From: Laura Gibbons
Sent: 24 October 2018 14:50
To: Planning.Responses
Cc: Michael Eastham
Subject: RE: Planning Consultation on: AL/103/18/PL

Engineers Comments Regarding Surface Water Drainage

APPLICATION NO: AL/103/18/PL

Site Address: L'Apache Westergate Street Westergate PO20 3SQ

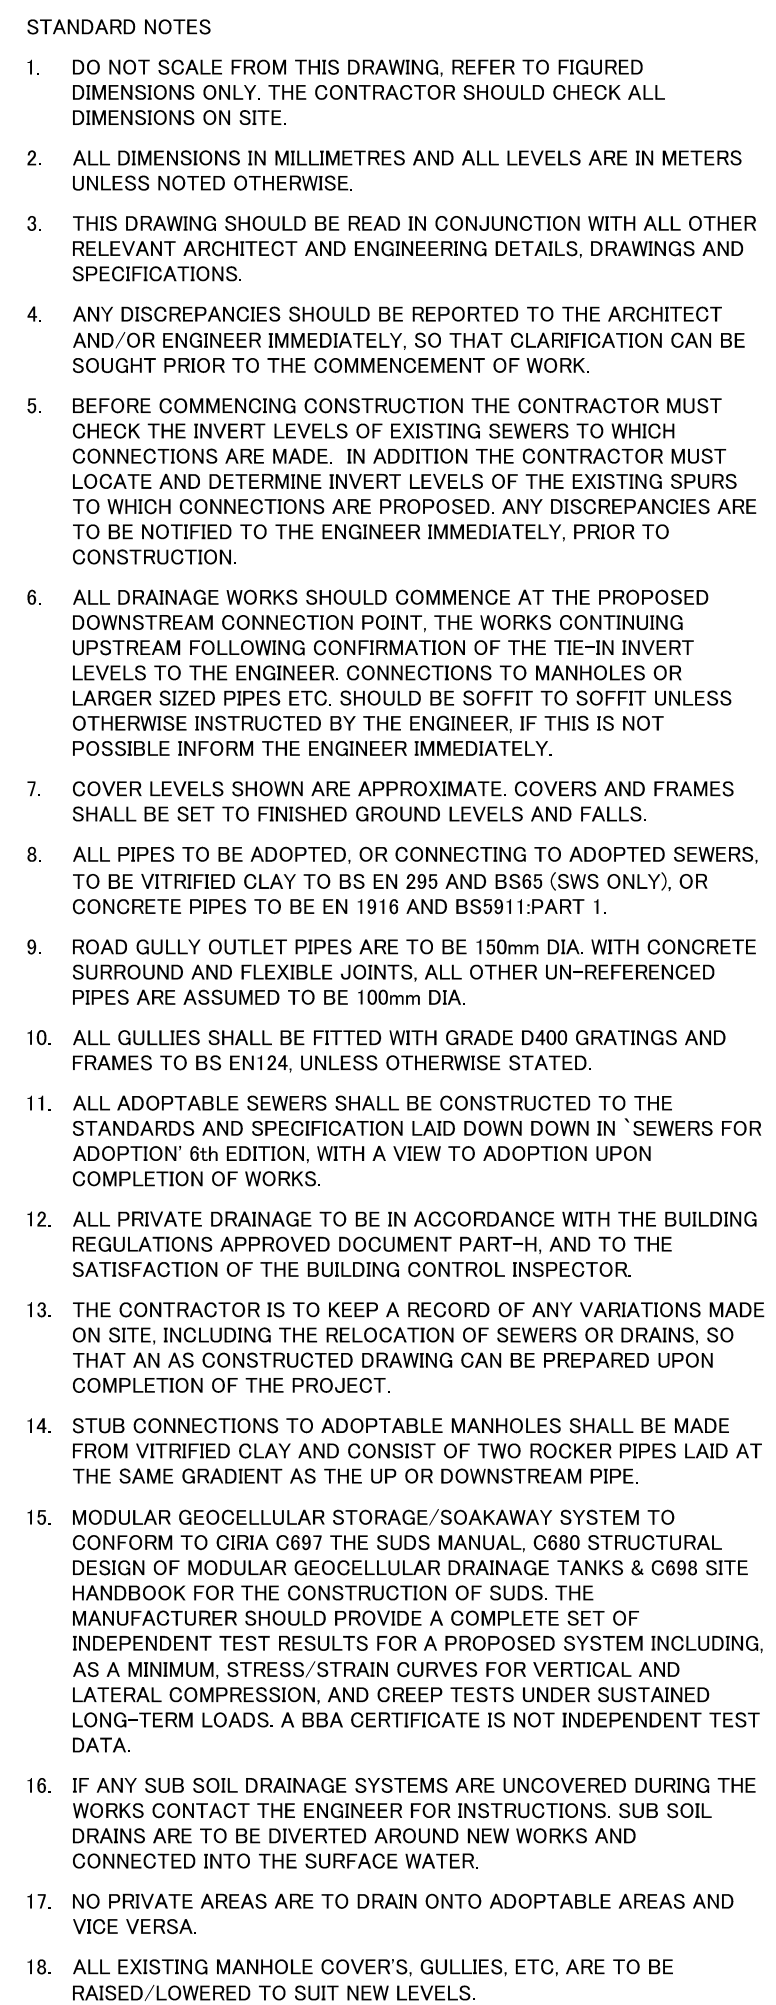
The applicant has submitted preliminary drainage proposals which presume an infiltration rate of 1×10^{-5} . I suspect that the actual rate found during winter testing will be lower than this. Winter groundwater monitoring should also be completed to ensure that the base of infiltrating structures is set above the maximum groundwater level.

Infiltration rates for soakage structures are to be based on percolation tests undertaken in the winter period and at the location and depth of the proposed structures. The percolation tests must be carried out in accordance with BRE 365, CIRIA R156 or a similar approved method and cater for the 1 in 10 year storm between the invert of the entry pipe to the soakaway, and the base of the structure. It must also have provision to ensure that there is capacity in the system to contain below ground level the 1 in 100 year event plus 40% on stored volumes, as an allowance for climate change. Adequate freeboard must be provided between the base of the soakaway structure and the highest recorded annual groundwater level identified in that location.

Any SuDS or soakaway design must include adequate groundwater monitoring data to determine the highest winter groundwater table in support of the design. The applicant is advised to discuss the extent of groundwater monitoring with the Council's Engineers. Supplementary guidance notes are also enclosed for information.

Please apply **ENGD2B** and **ENGD4A**.
